3/2022/0279 and 3/2022/0278 Talbot Hotel Chipping

**Subject:** RE: 3/2022/0279 and 3/2022/0278 Talbot Hotel Chipping

4. Talbot Hotel – the replacement extension has been omitted to retain the existing. As mentioned I have removed the modern and unsympathetic hipped roof to continue the existing section of parapet roof style which I feel better reflects the existing and exposes more of the external wall and dominance of the former roof structure.

6521 - P02

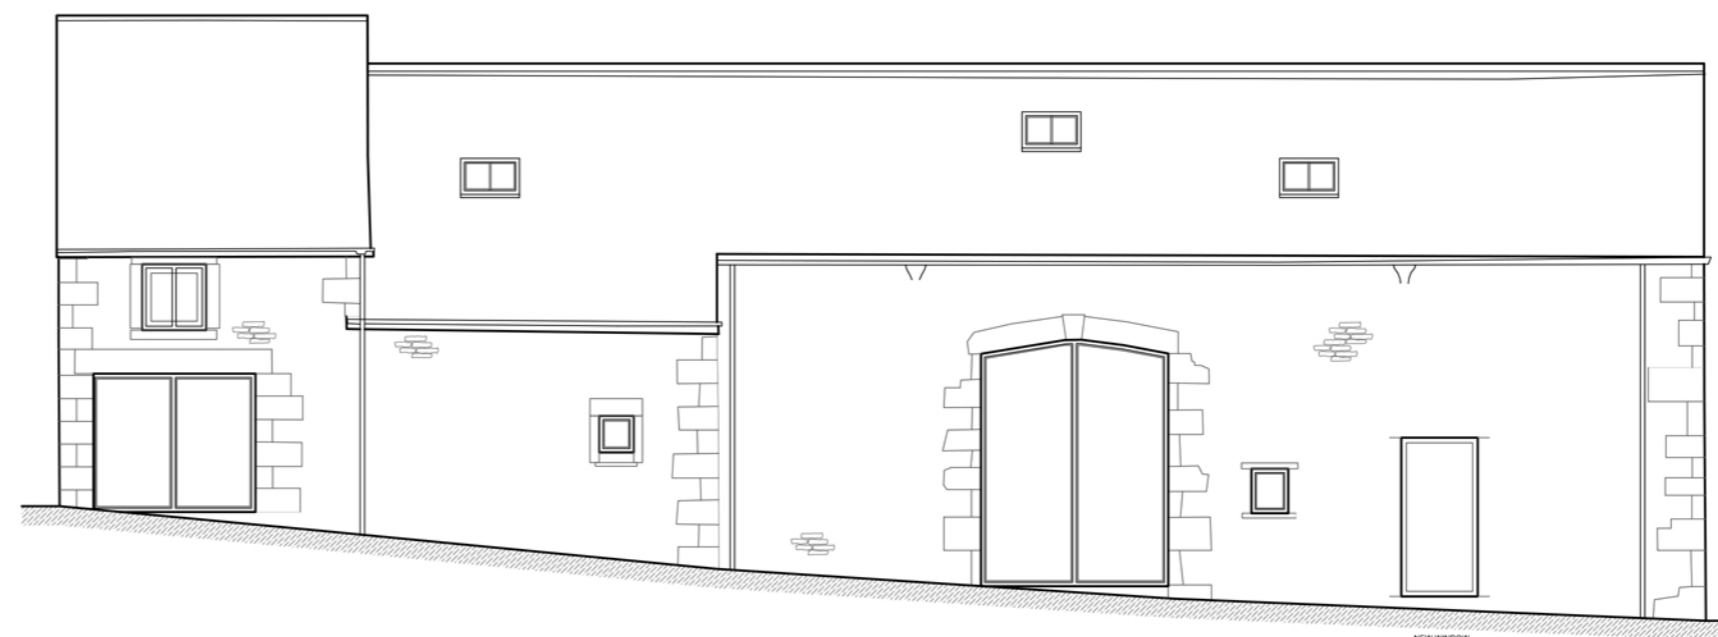
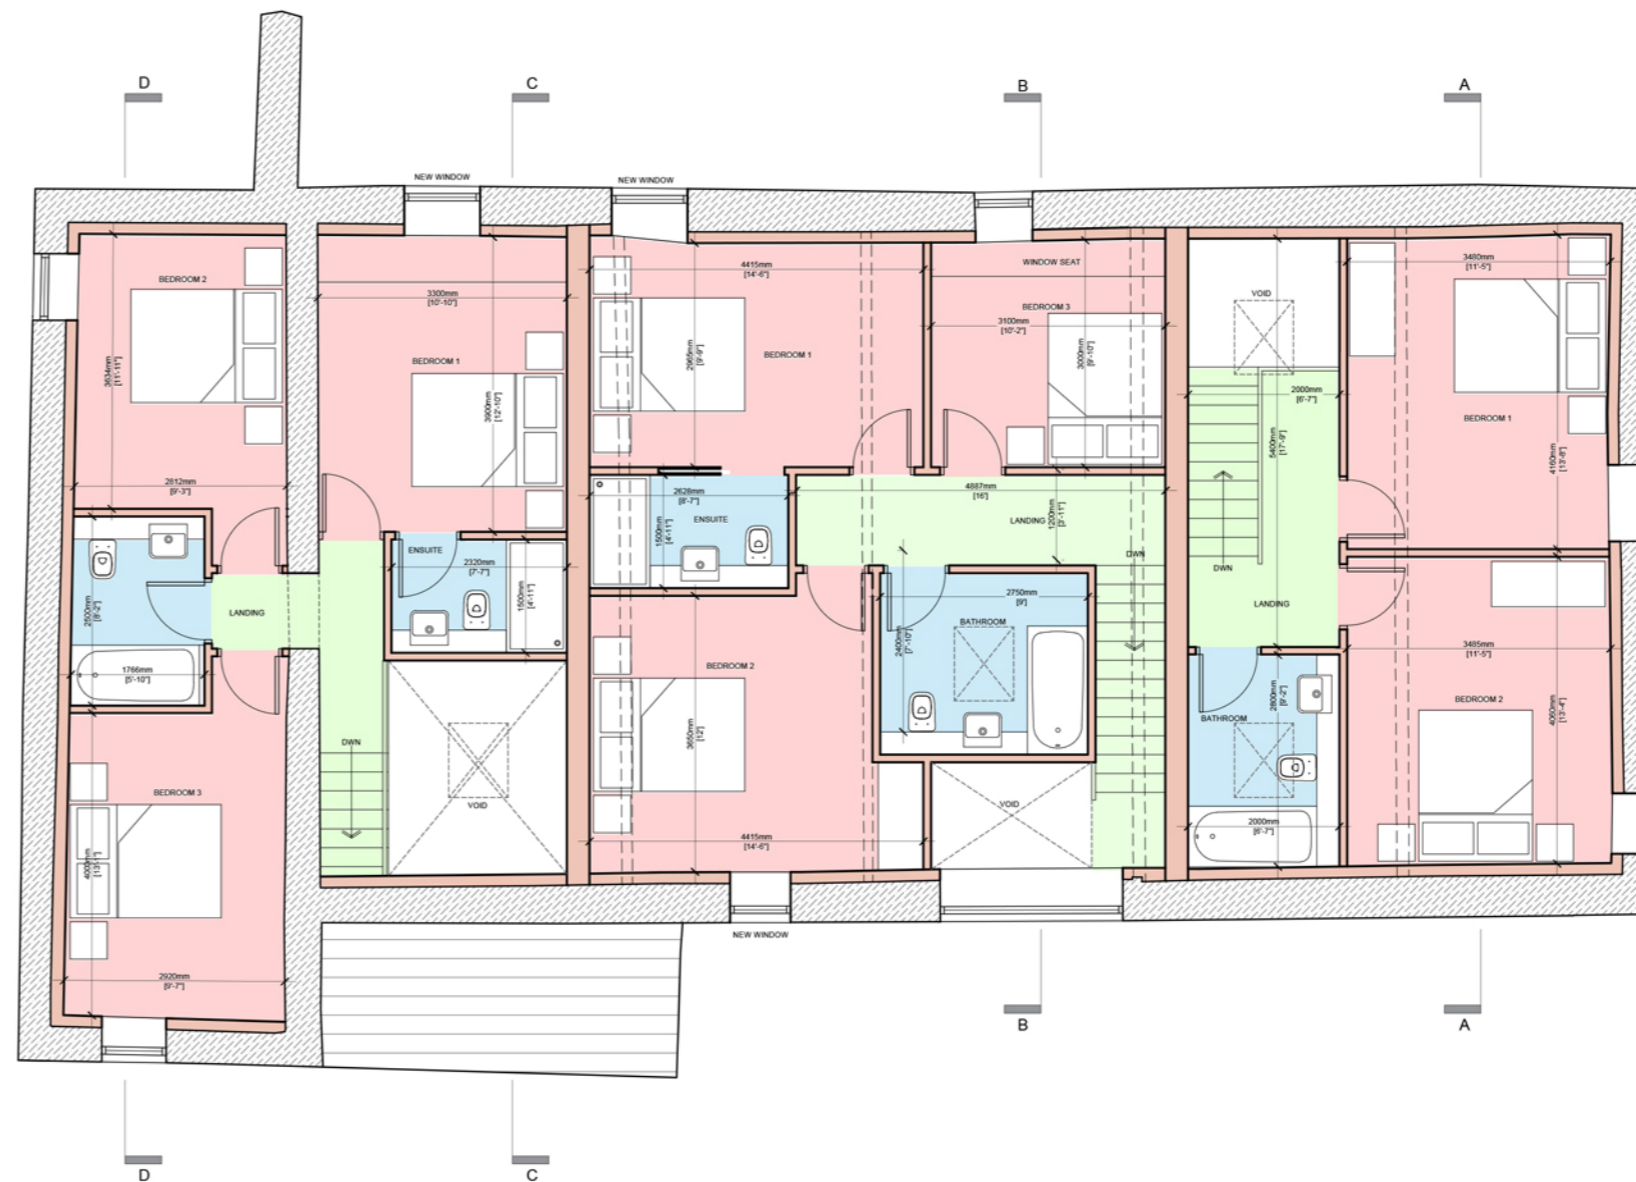
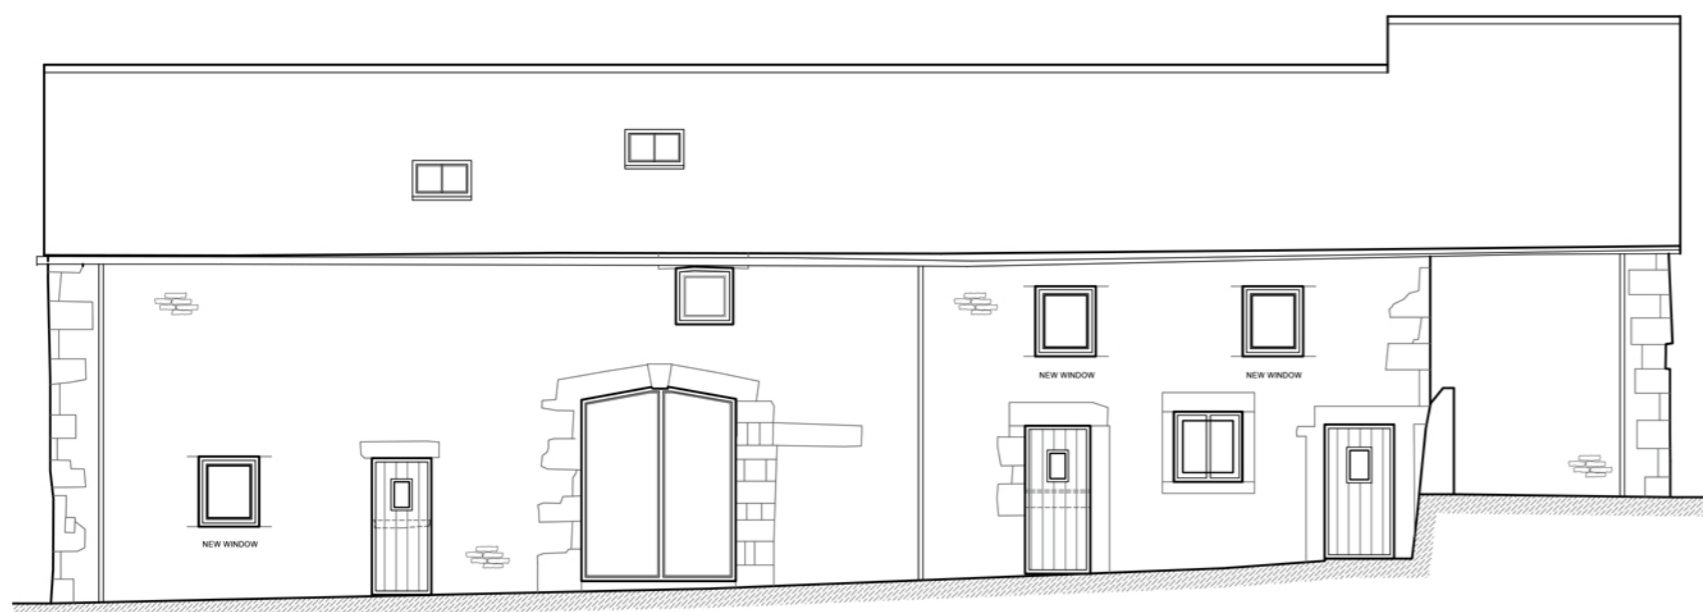
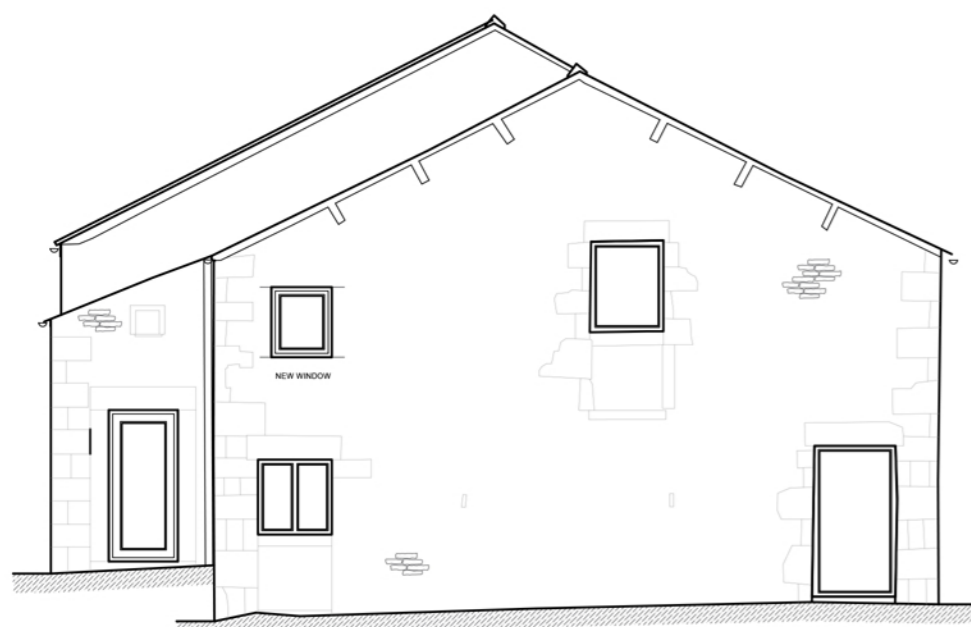
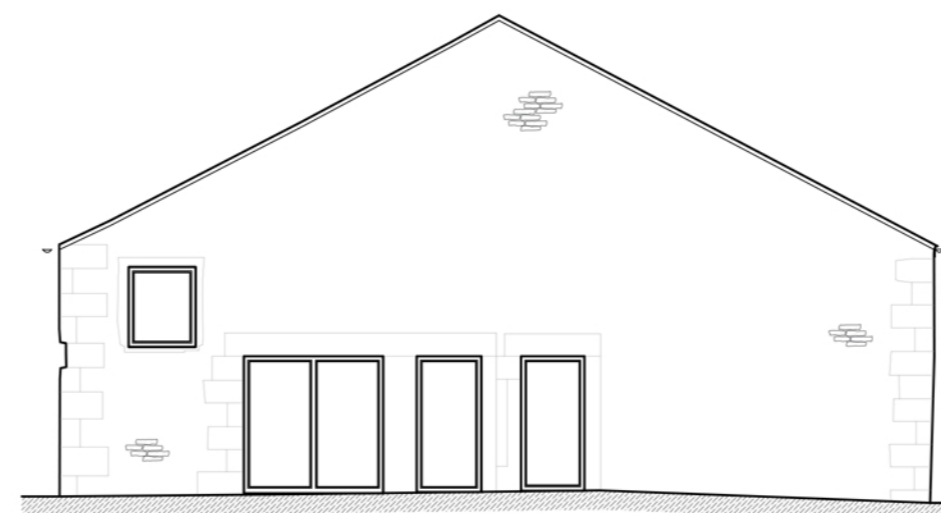
5. Timber gate and fence have been illustrated on drawing 6521-P04-B.
6. Barn amendments-
  - a. Rooflights have been rationalised and reduced, we have retained two which serve family bathrooms and do not feel this is to onerous given other conversions throughout the borough.

- b. Unit 1 front window removed.
  - c. Requested window details to be conditioned. Units will be painted timber with re-claimed stone surrounds.
  - d. Timber gate and fence have been illustrated on drawing 6521-P04-B.
